ENG-SP20008-R4-PrelimPlan-redlines.pdf Markup Summary

HOMESTEAD NORTH AT STERLING RANCH
 PRELIMINARY GRADING PLAN
 SHEET 14 OF 25
 JOB NO. 25188.00

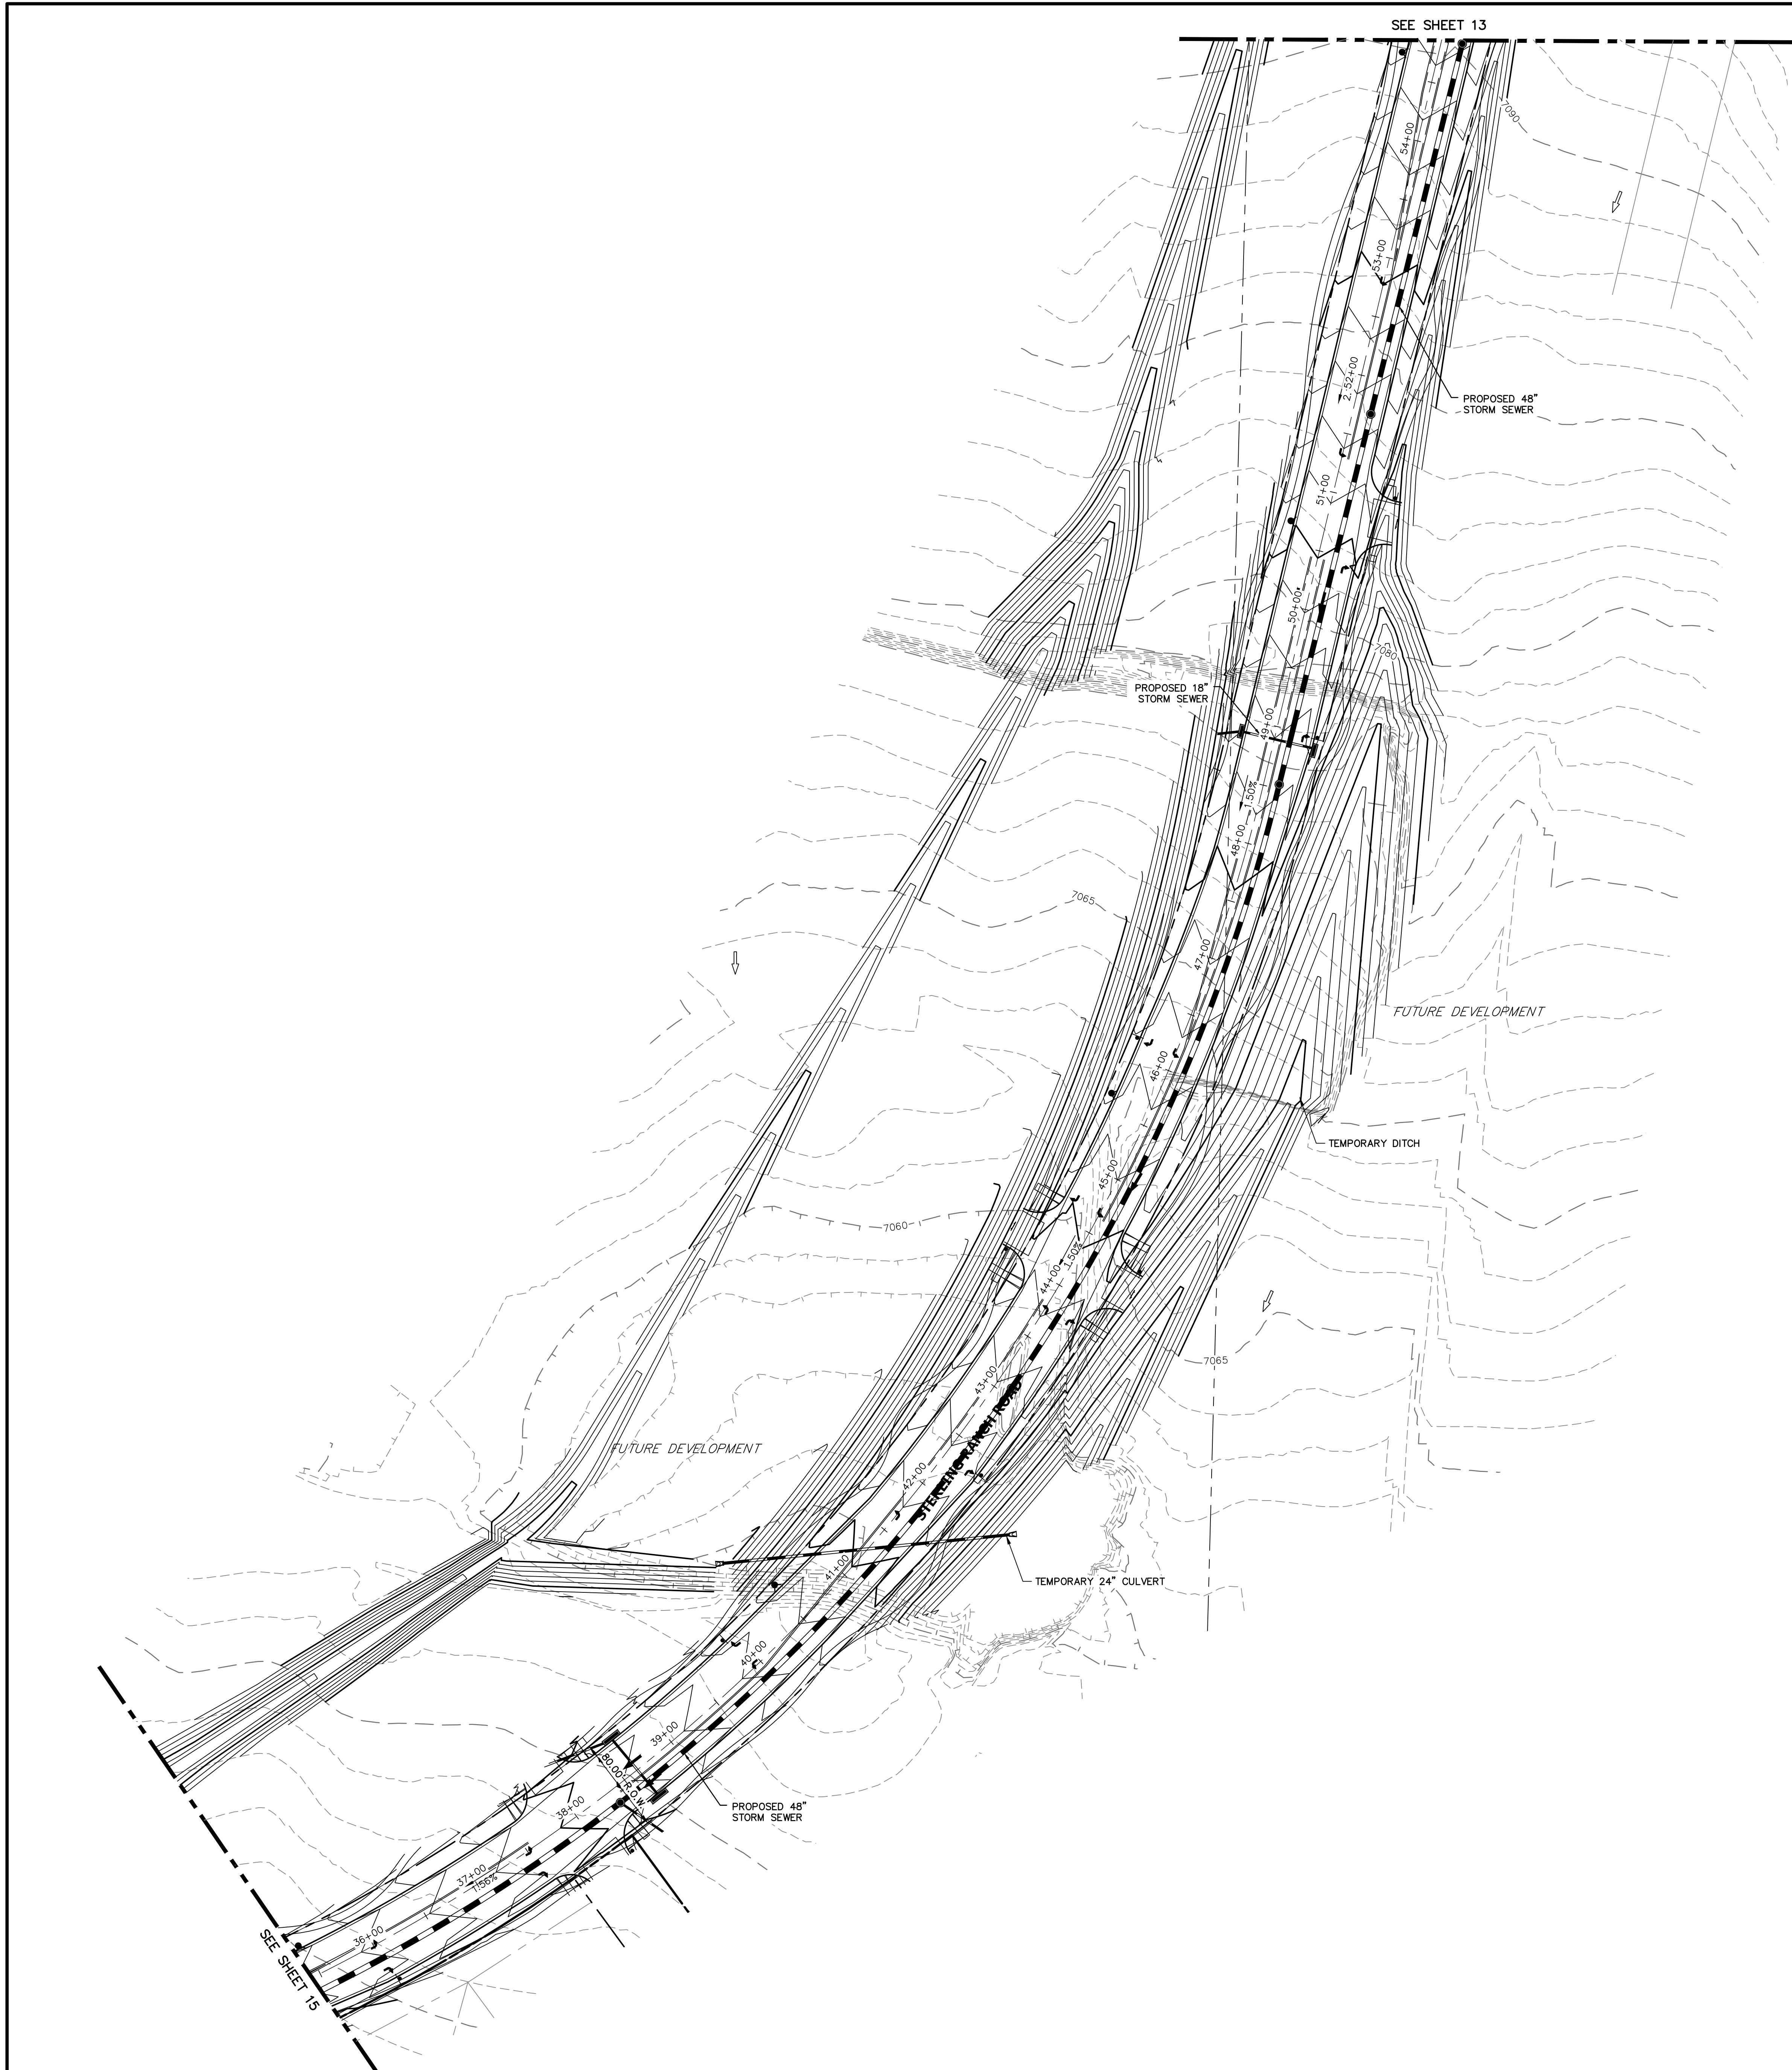
Show culvert

PRELIMINARY PLAN

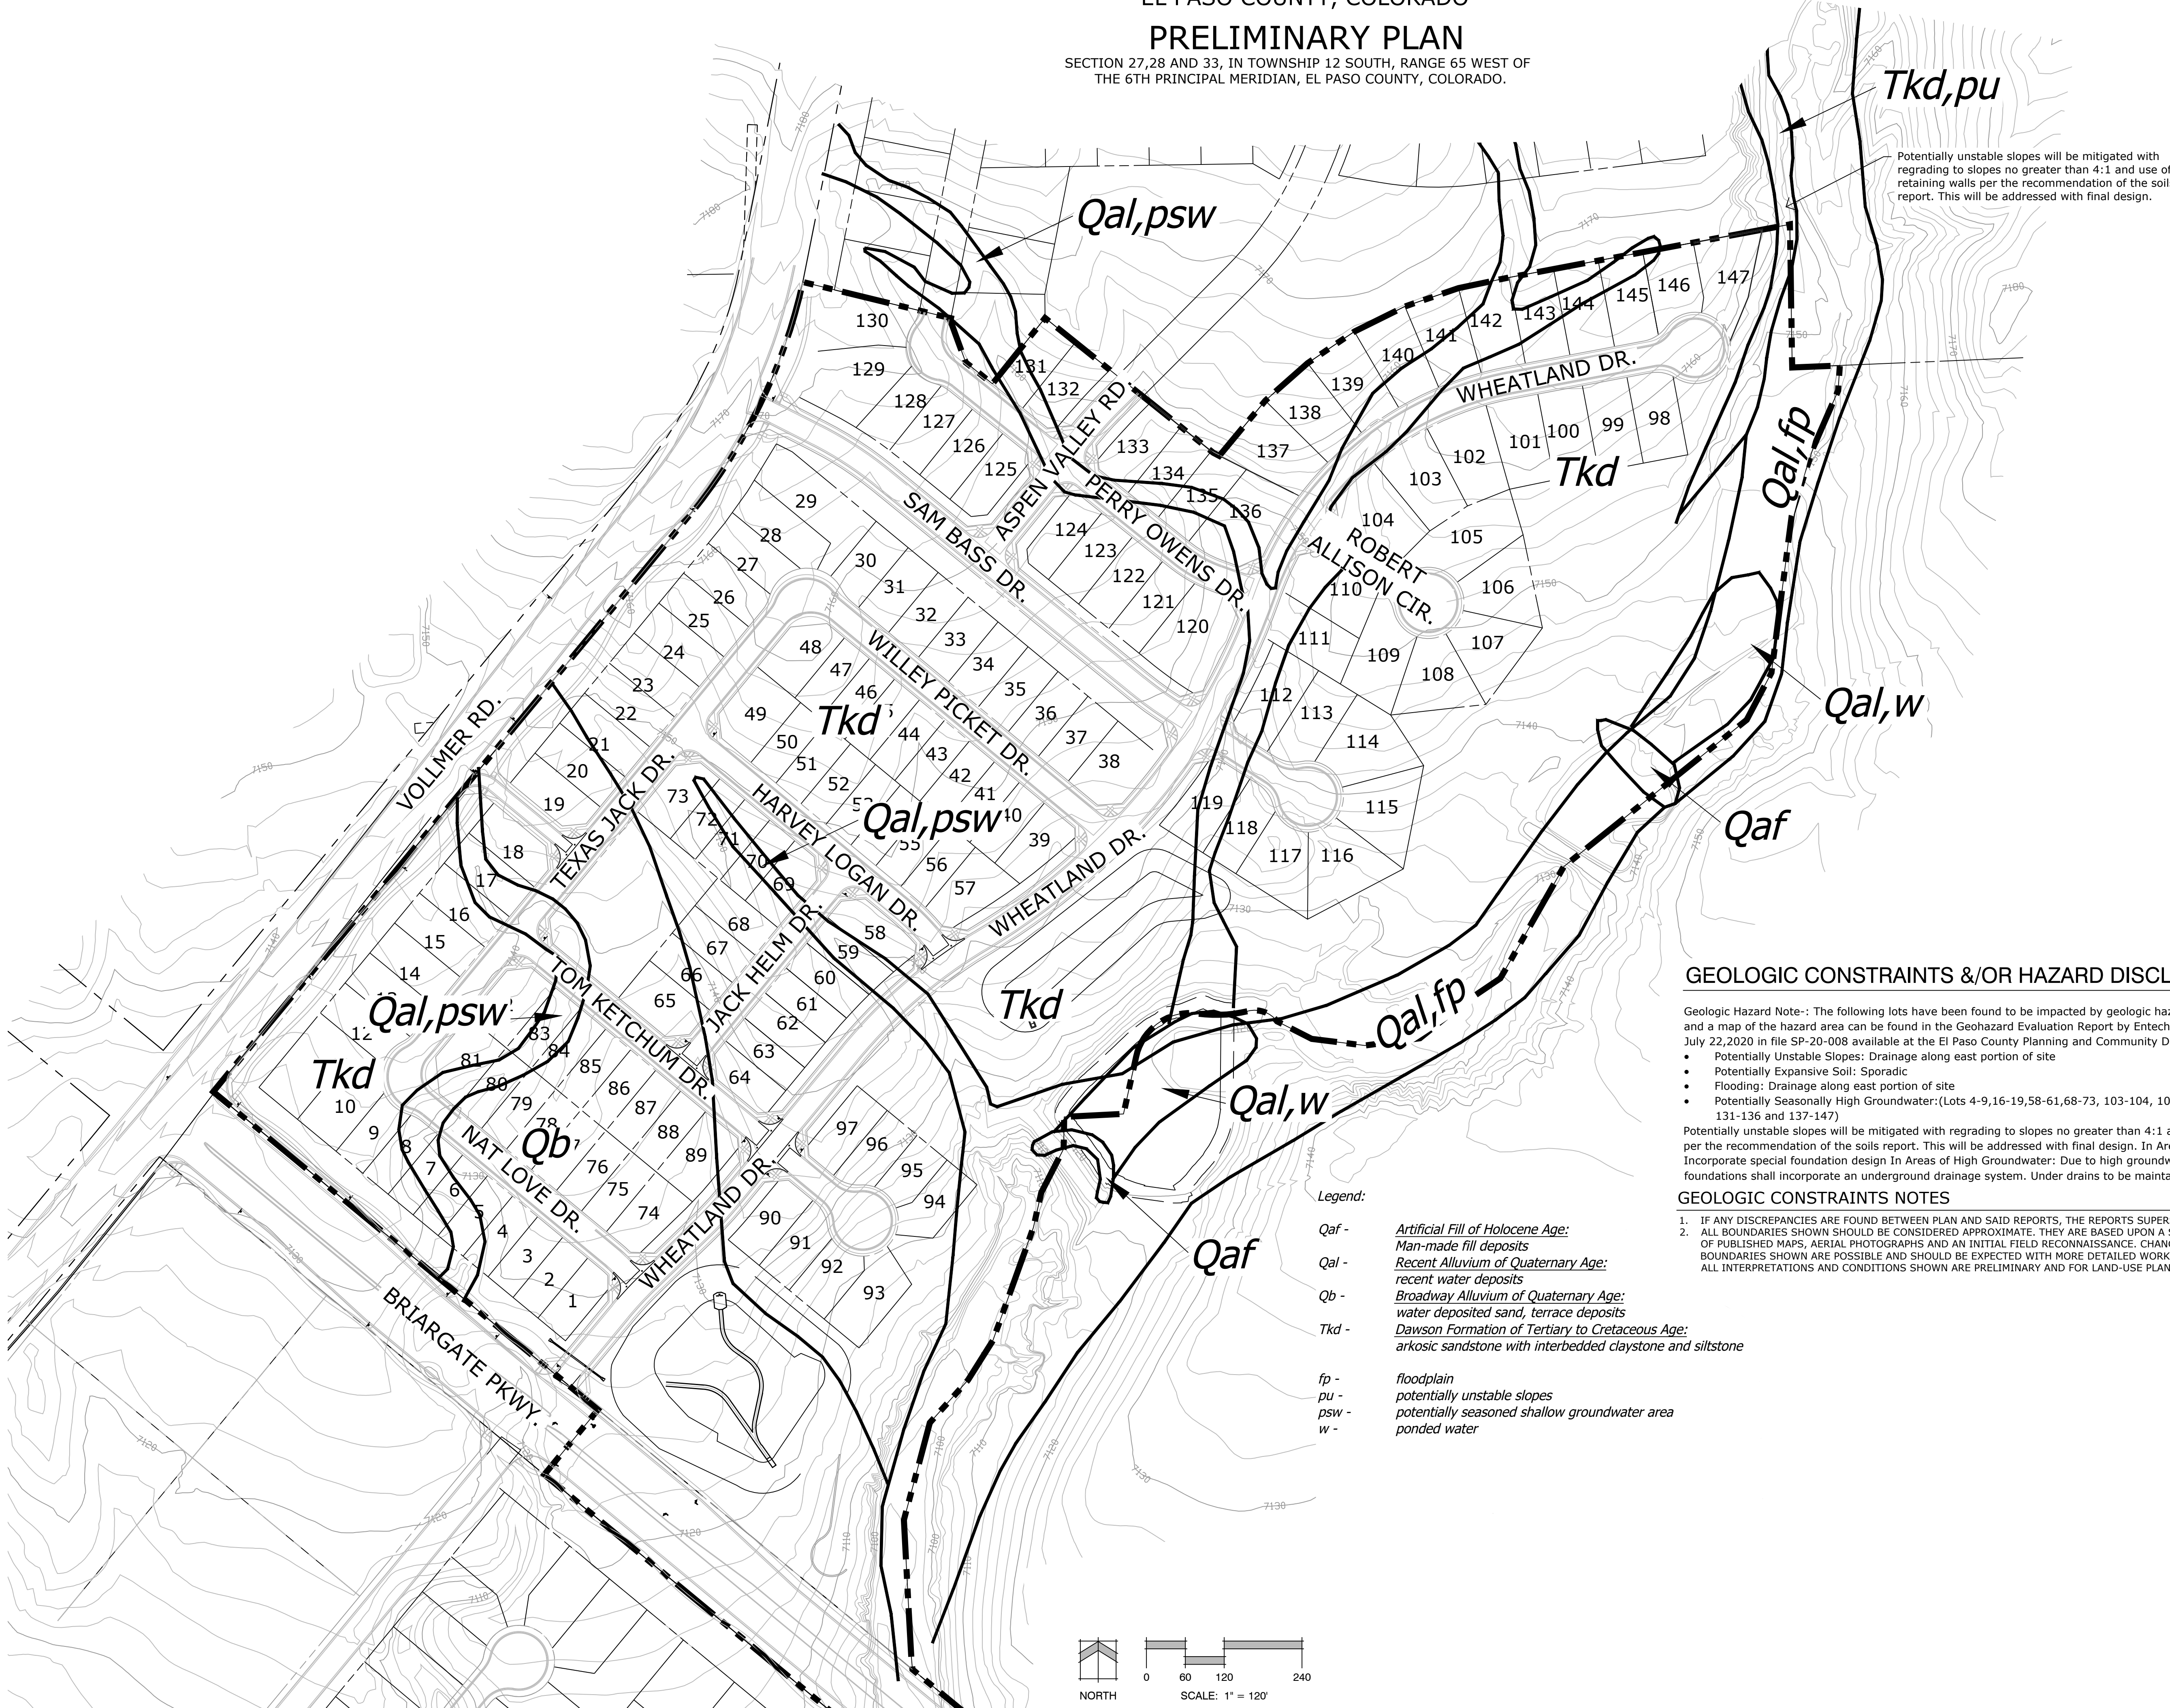
Potentially unstable slopes need to be addressed. How far west does stabilization need to go? Add a note that this will be addressed with final design.
